Demolition of existing dwelling & the erection of 7No. residential dwellings, with associated parking, amended access location from Lime Tree Close & landscaping.

Scorton 9 Lime Tree Close East Preston

Thank you for your internet representation made on 16th May 2018 which has been recorded as **'an objection'** with the comments as follows:

Drawing ref: LTC.PLOT7.001

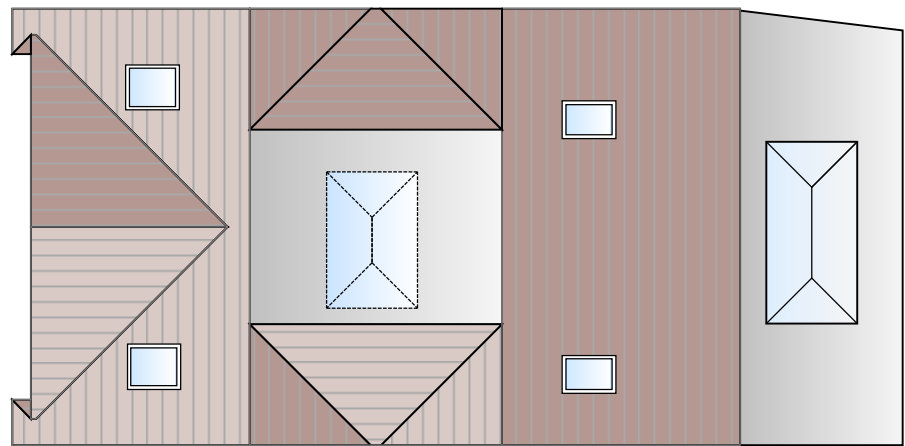
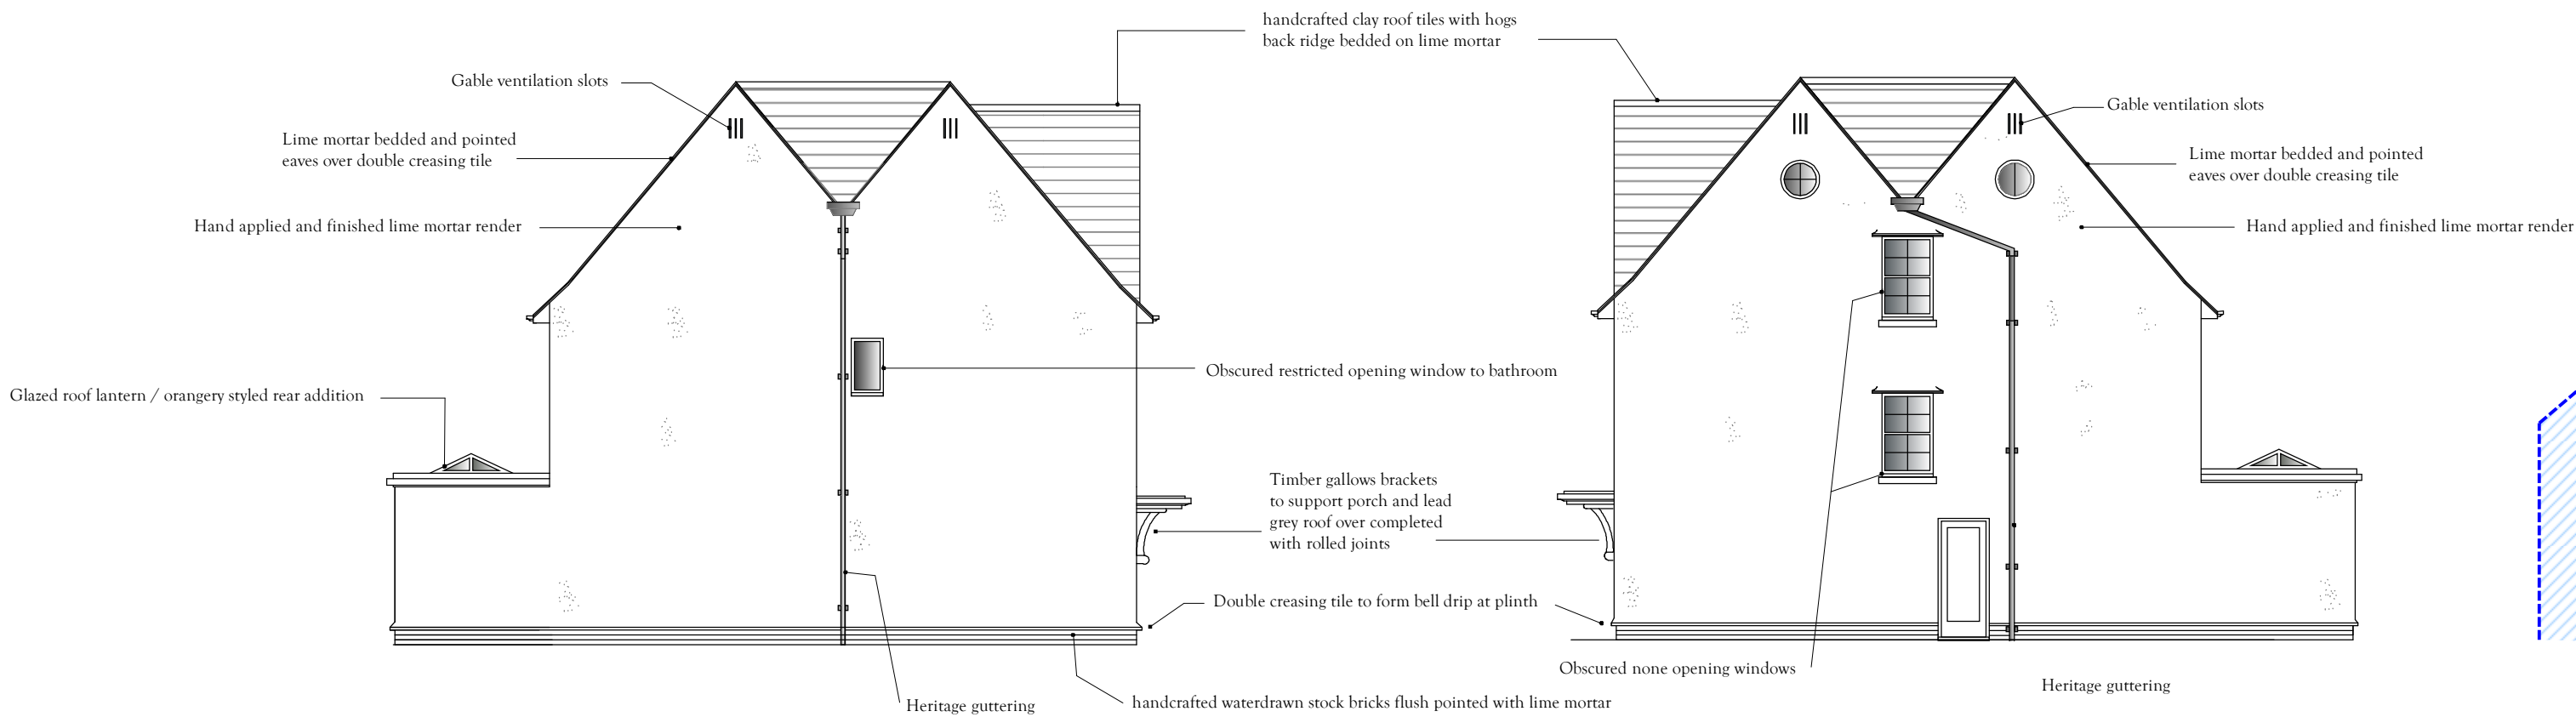
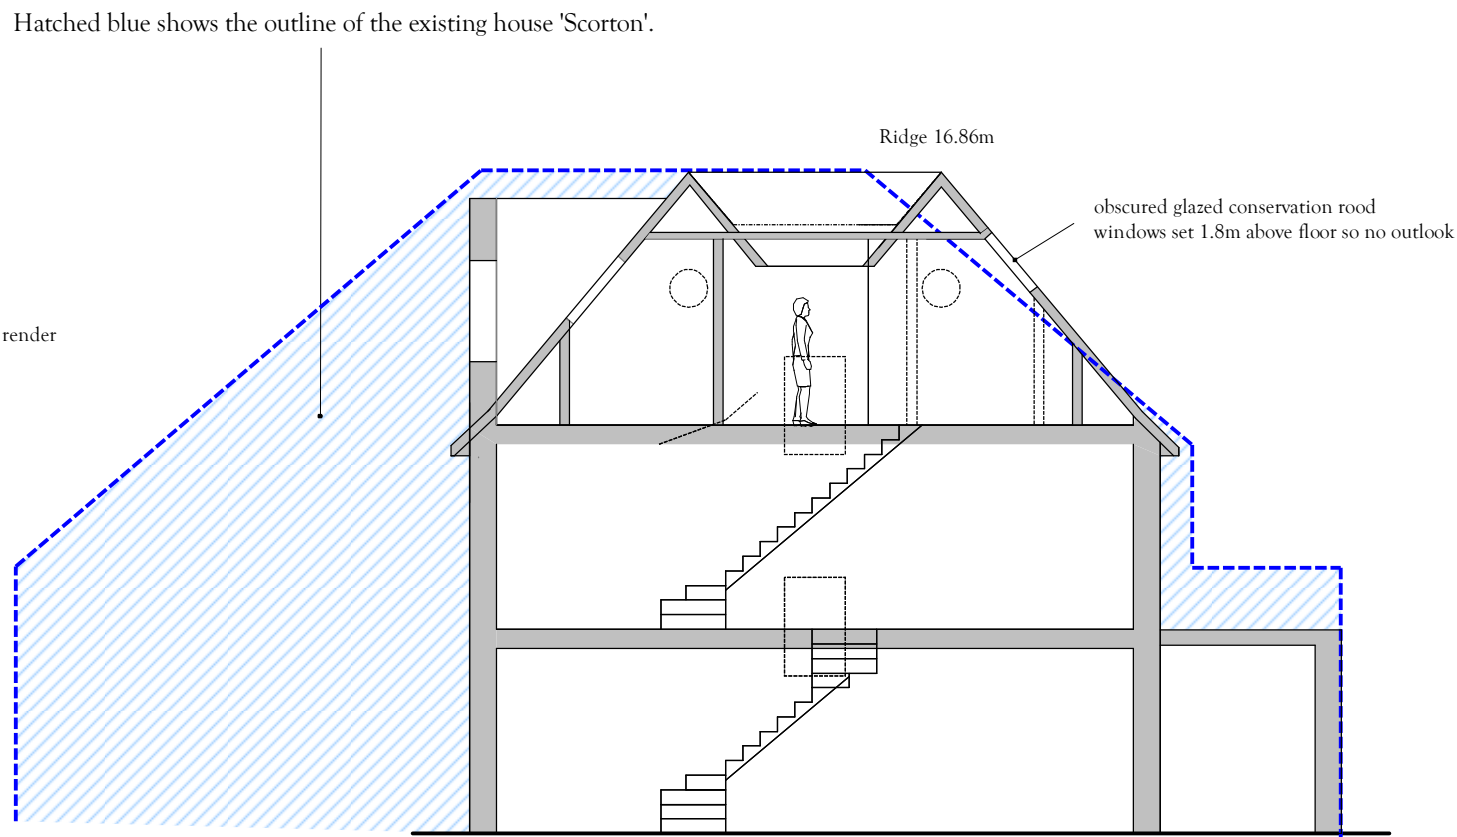
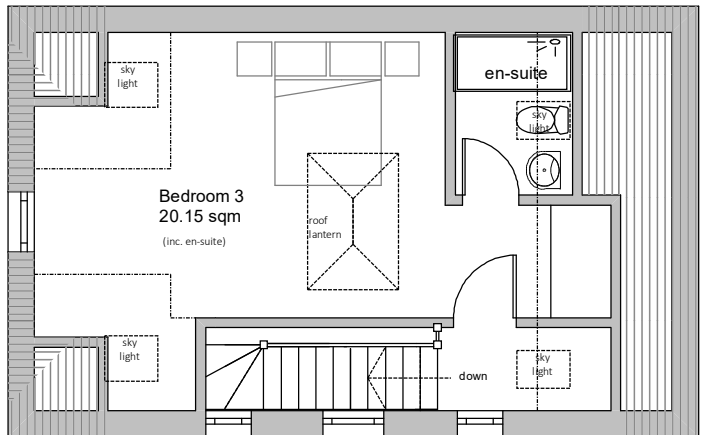
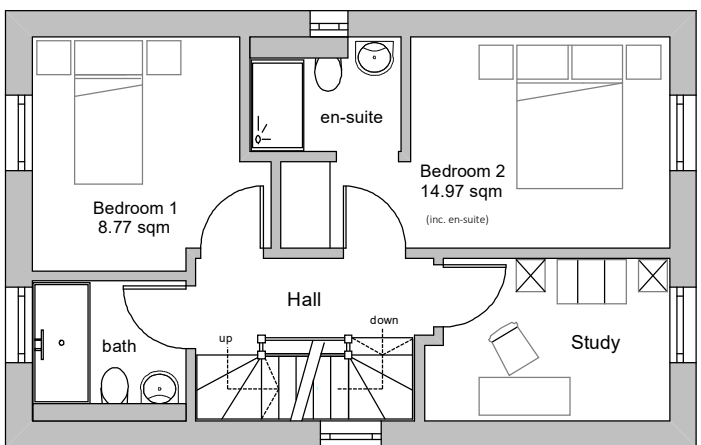
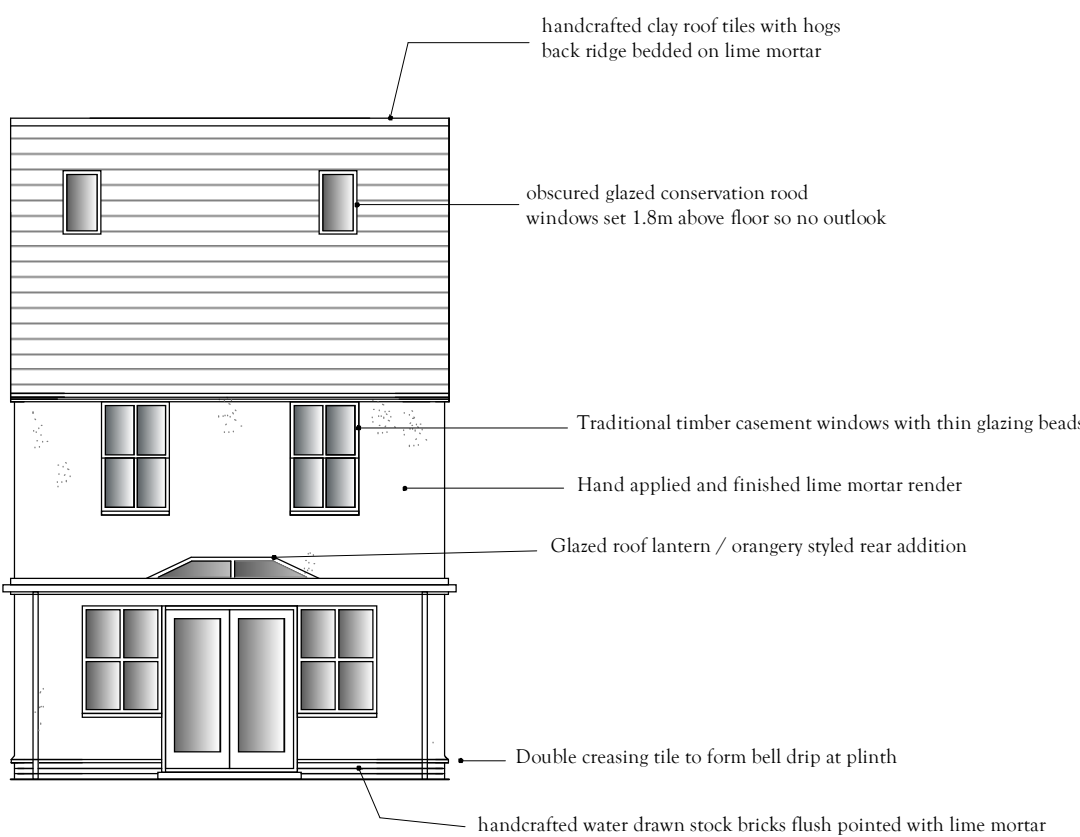
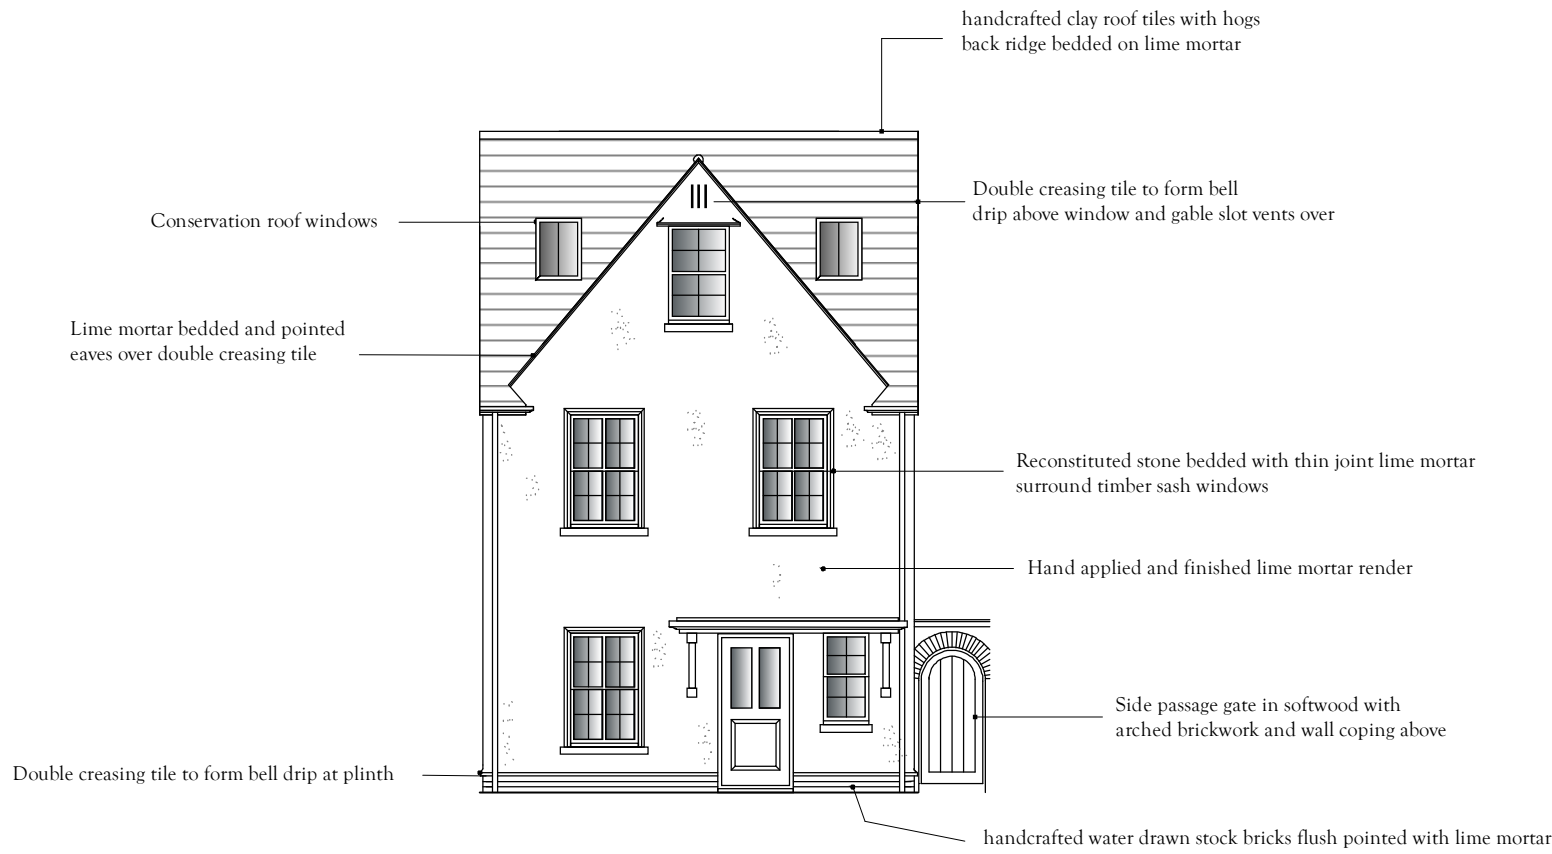
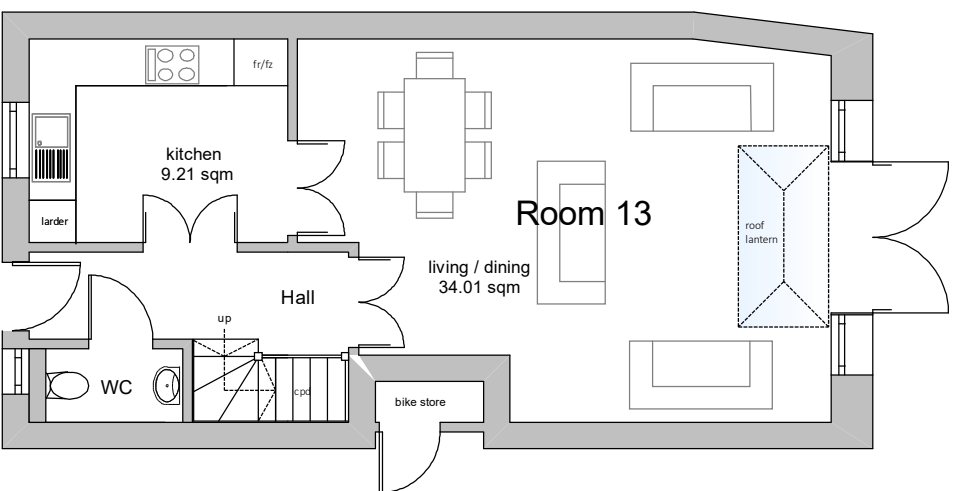
On a different subject, the PLAN for Plot4 show the house design for Plot 7 and the PLAN for Plot 7 shows the house design for Plot 4. This is misleading. Plot 4 is very different from plot 7 in that it has a two storey extension to the south side.
